Application No: K/12/22/HH
Site Address: Meadow House Kingston Lane Kingston BN16 1RS
Description of works: Erection of single storey rear and front porch extension, erection of self contained detached annex and alterations to fenestration.

Thank you for your internet representation made on 20th May 2022 which has been recorded as an objection with the comments as follows:

PROPOSED EAST ELEVATION 1:50

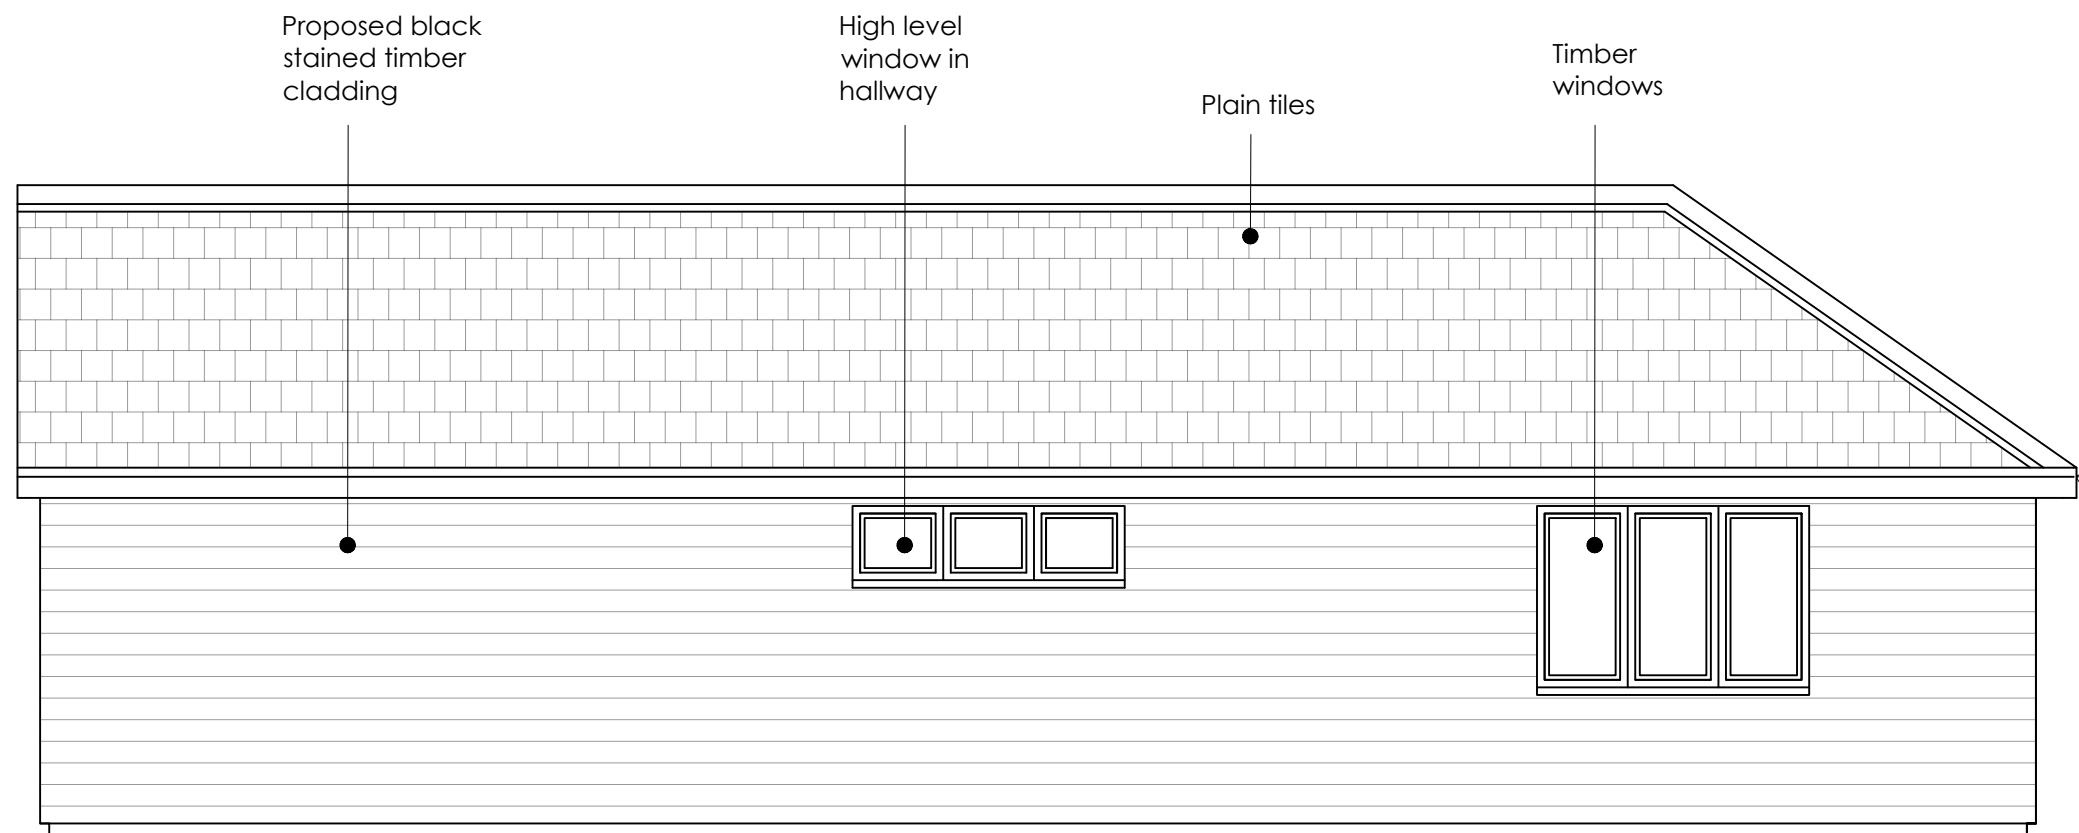
- Council does object to the creation of a self contained annexe by the conversion of a stable block

1. The stable block was approved in 1984 (planning application K/12/84) and is for equine use. This proposal represents a change of use on a site that is outside of the built up area boundary and in the Gap between Settlements that is predominantly agricultural countryside.

4. The stables are built on a 'dink' into the neighbouring field that is used for grazing horses and residential use could impact on this.

5. Council considers that the proposed annexe is too far from and detached from the main residence to be considered subservient to or ancillary to the main dwelling. It would be a separate dwelling.

7. Windows to the east elevation could overlook and would be in close proximity to the neighbouring field used for grazing. Windows should be obscure glass or with a condition that suitable screening fencing be installed in perpetuity.

Drawing Title: Proposed Extension

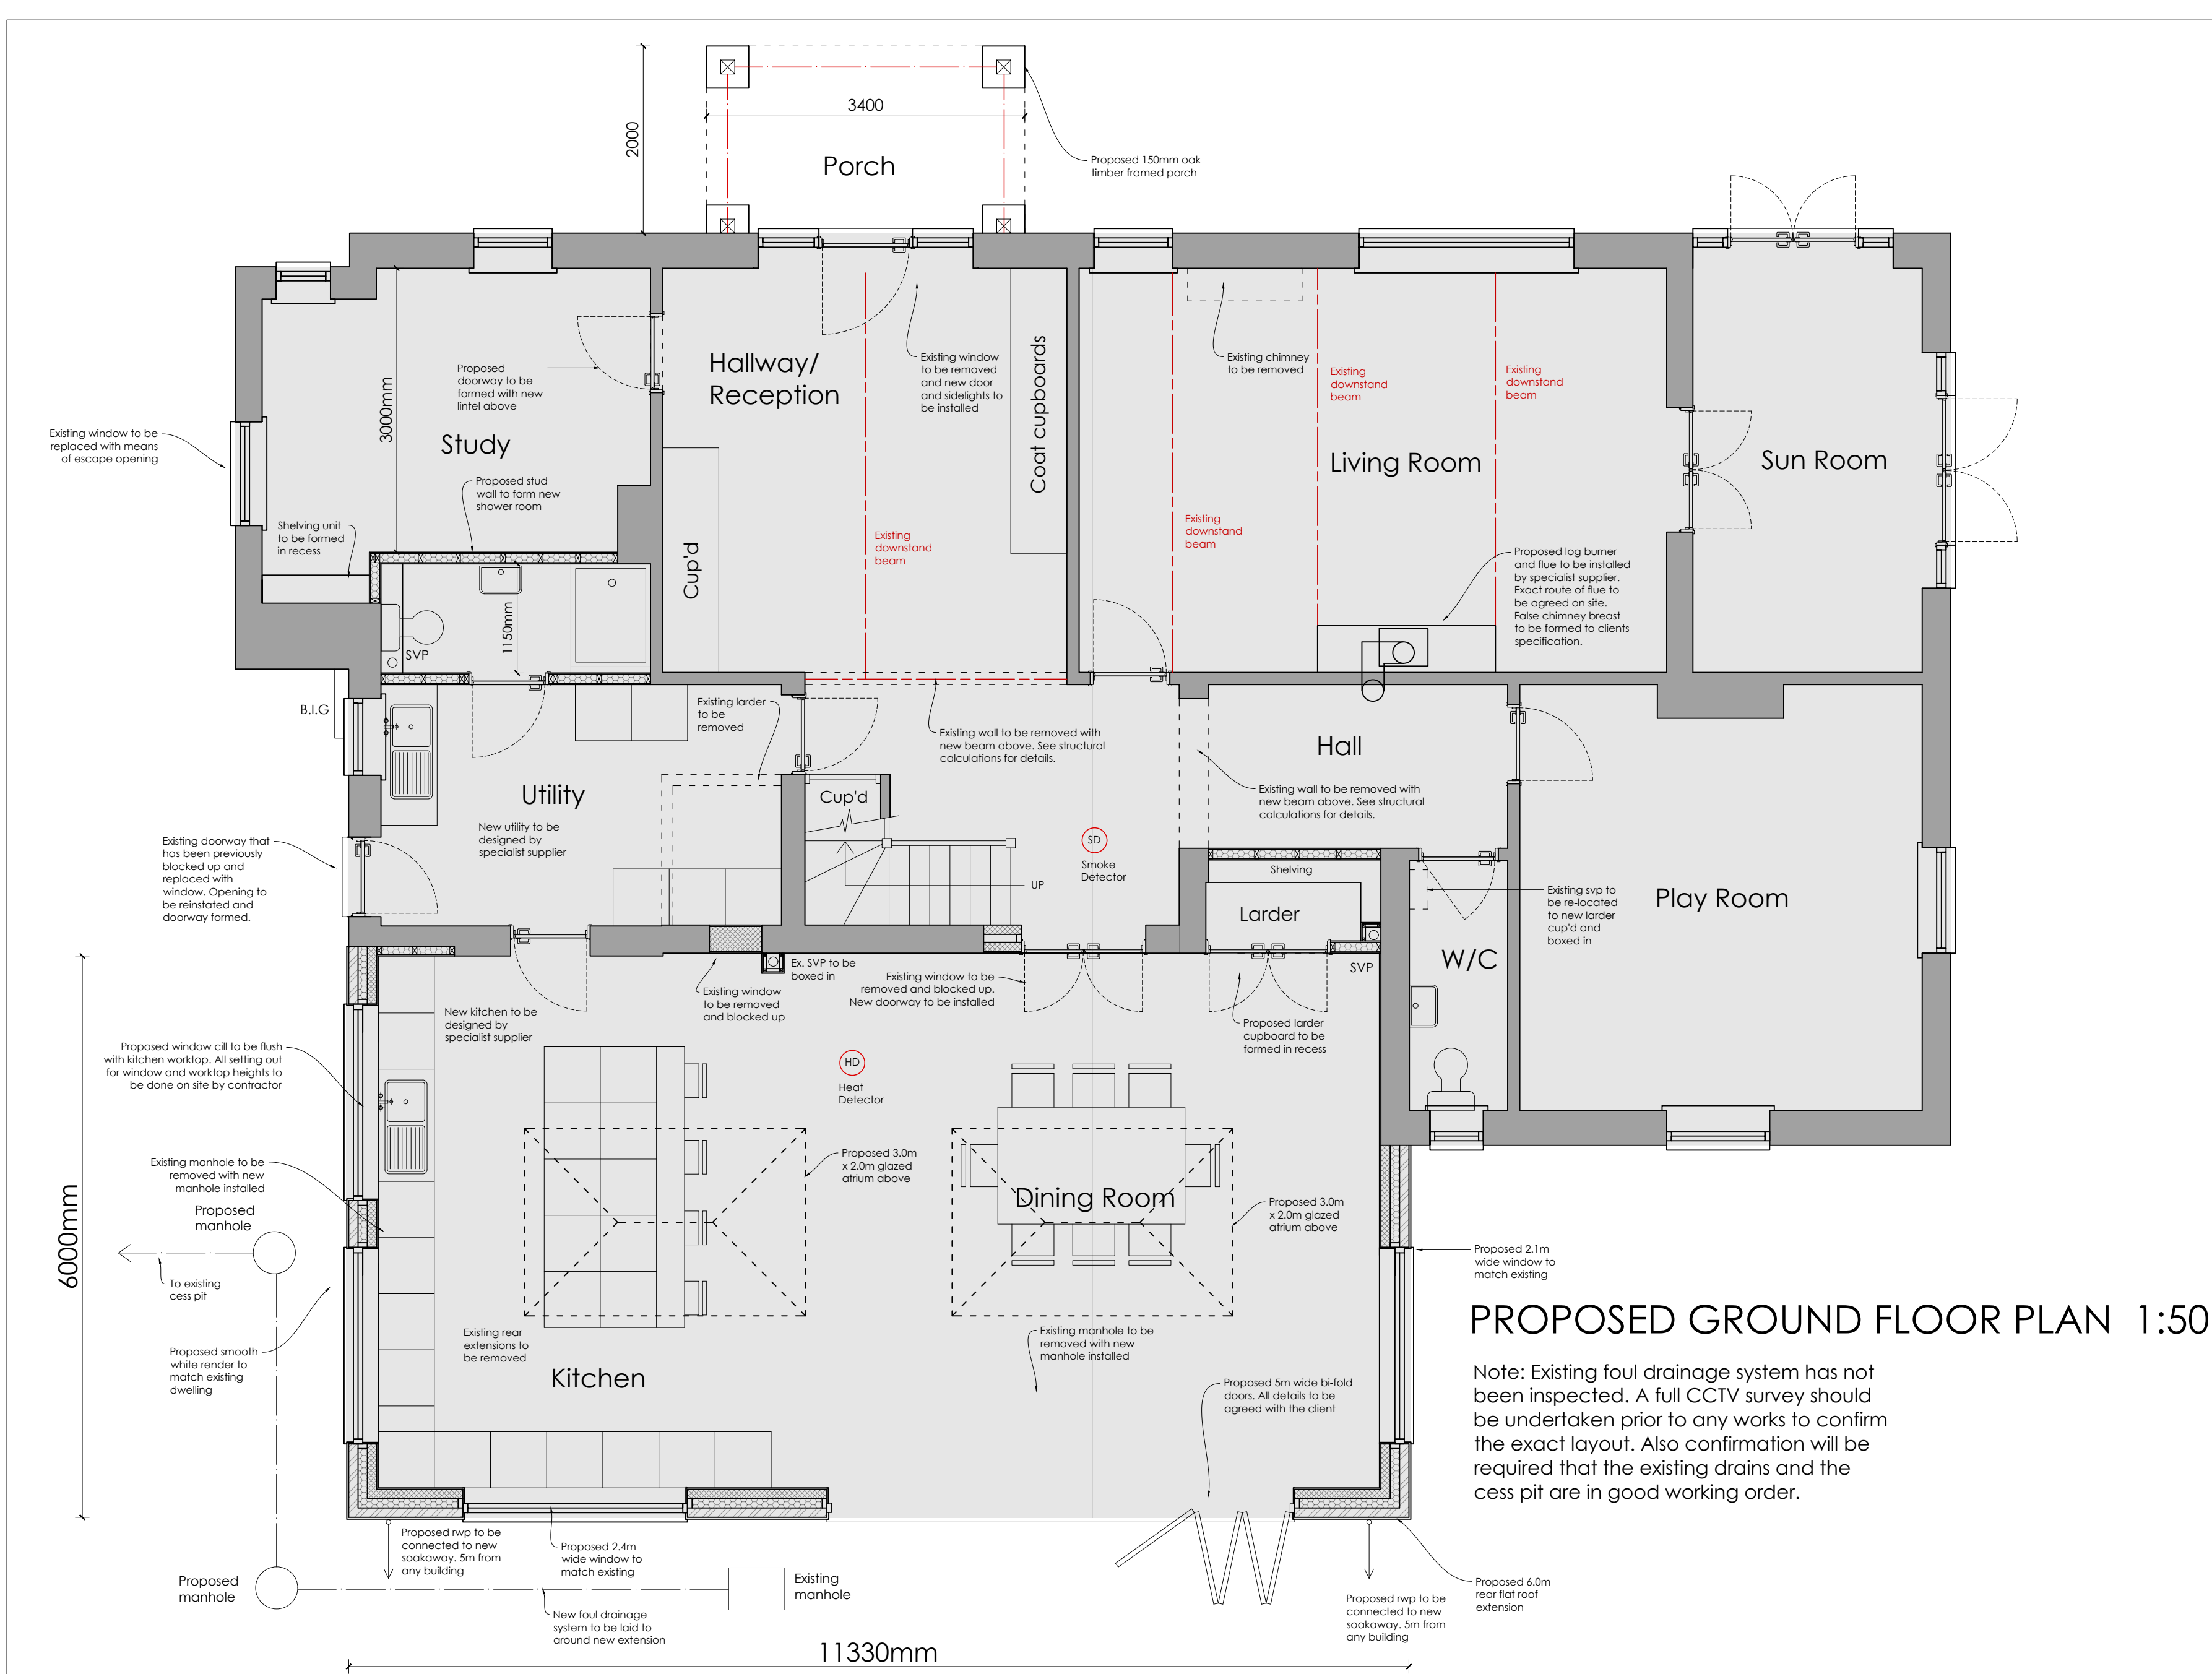
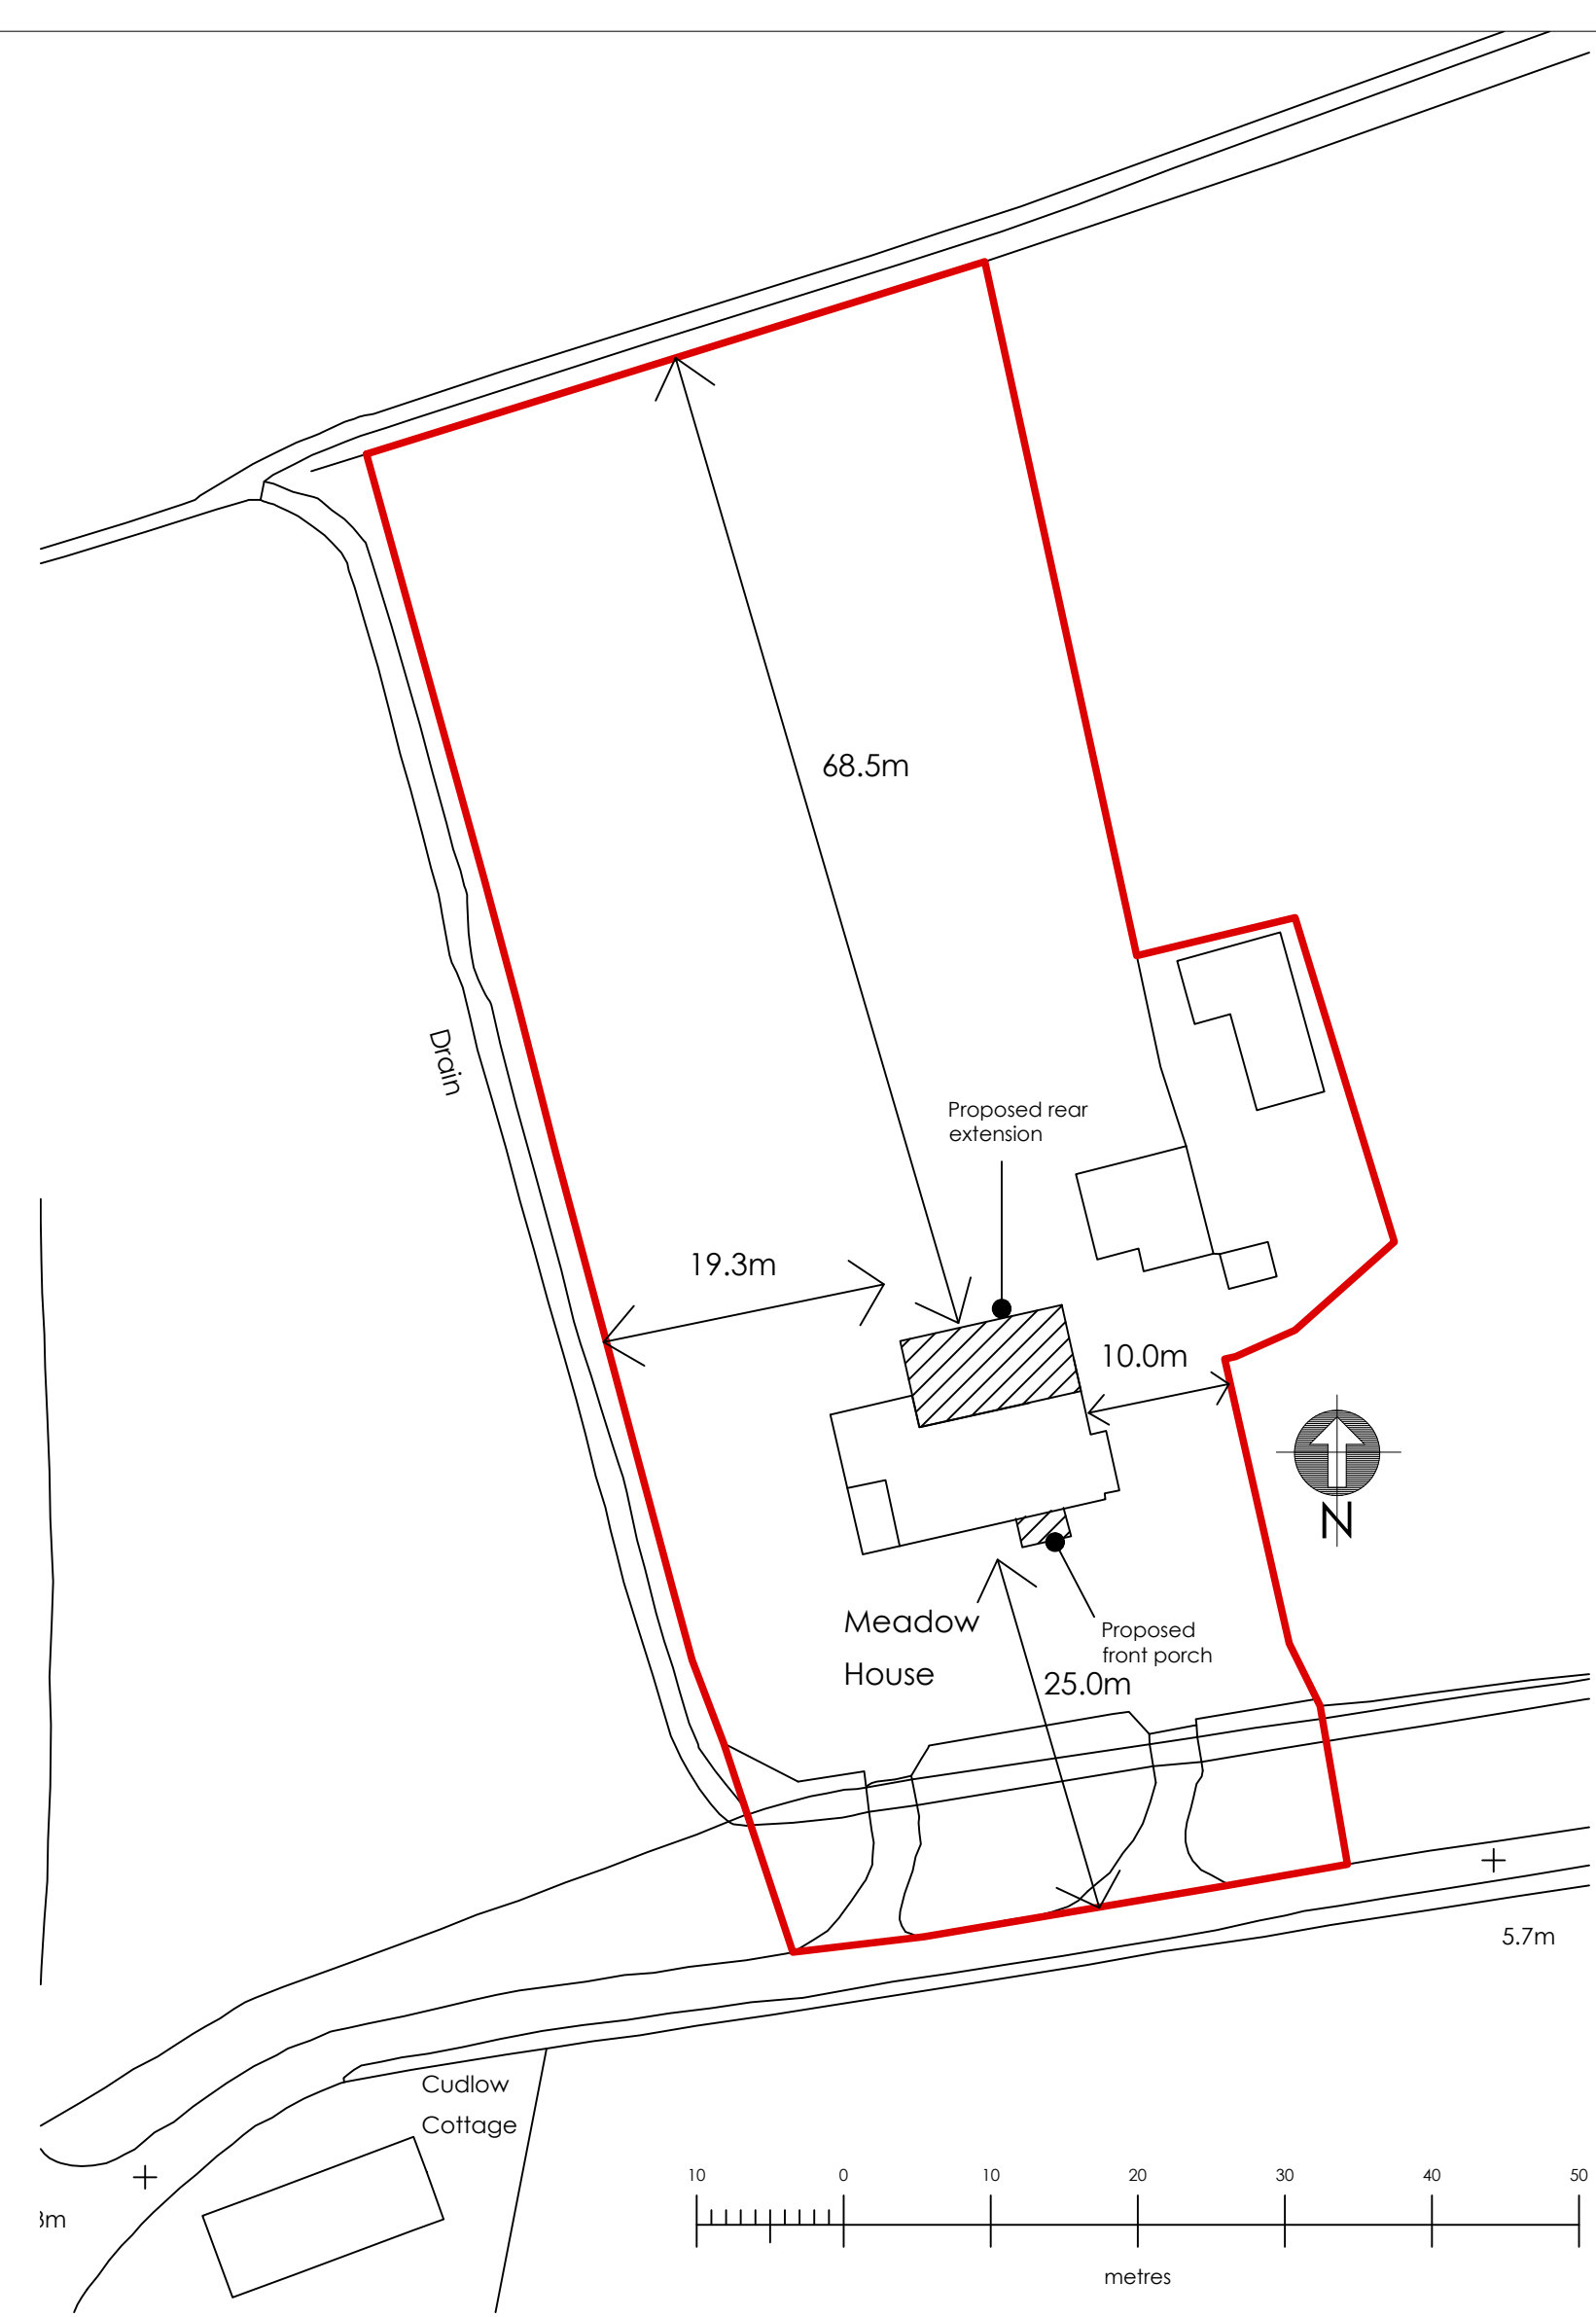
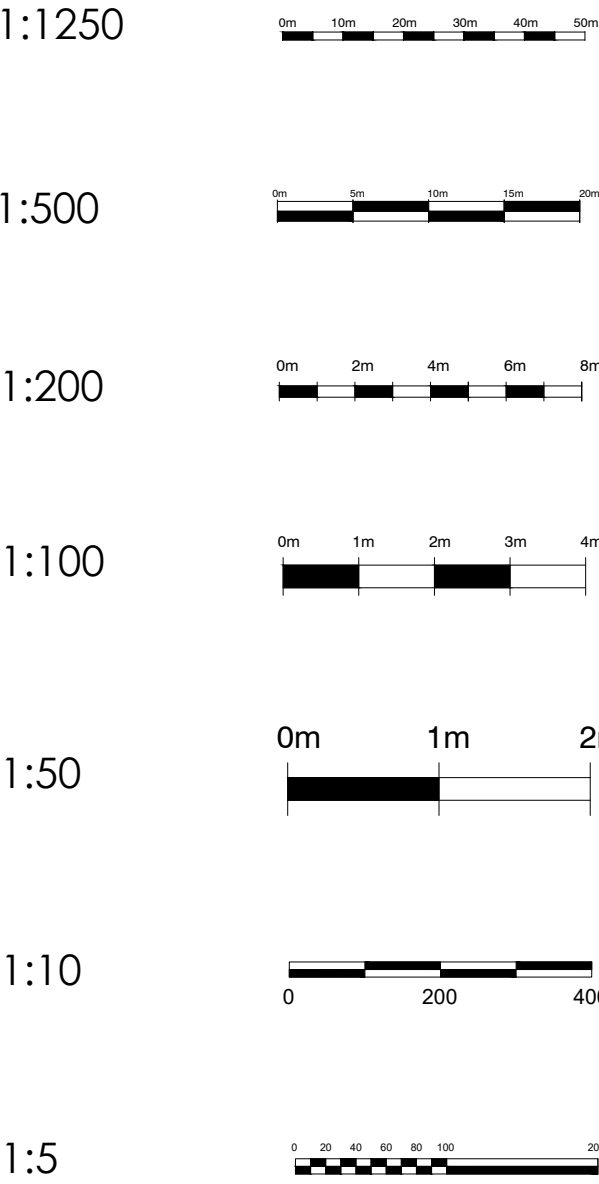
- Council has no objection in principle to the proposed rear extension and front porch extension to the existing dwelling but is concerned that a section of the 'U' shaped drive to the rear will be built over. It is essential that adequate parking and turning space is provided and clearly identified on a site map.

6. Will the section of the driveway to the east of the property that goes towards the existing garage be a dedicated access for the proposed annexe and possibly the separate existing garage? There is no site plan showing the layout.
